**APPROVED**  
Limited building only review  
Permit holder responsible for full compliance with the code

**JONATHAN THORTON**  
ADDITION

FIRST FLOOR PLAN
SCALE 1/4" = 1'-0"

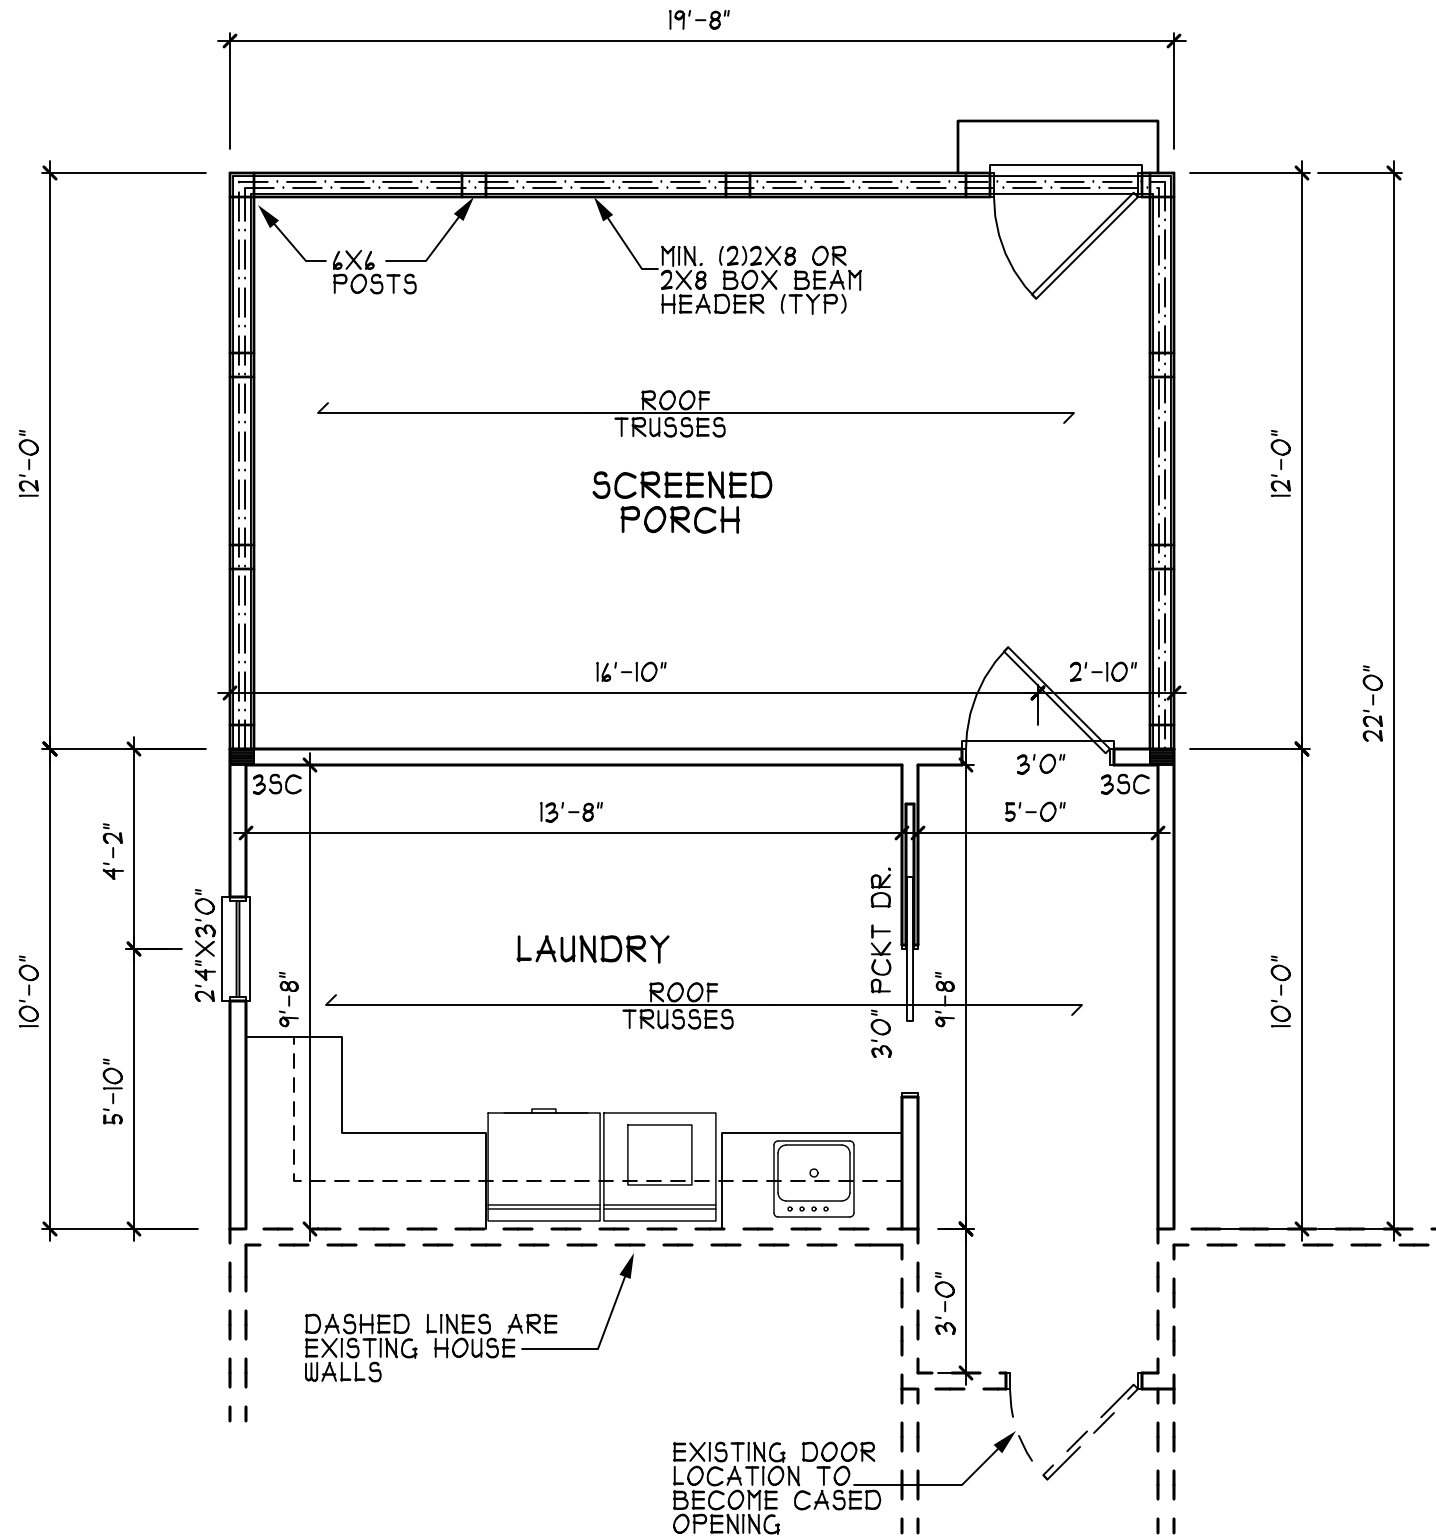
Verify addition is not closing off any sleeping room egress windows
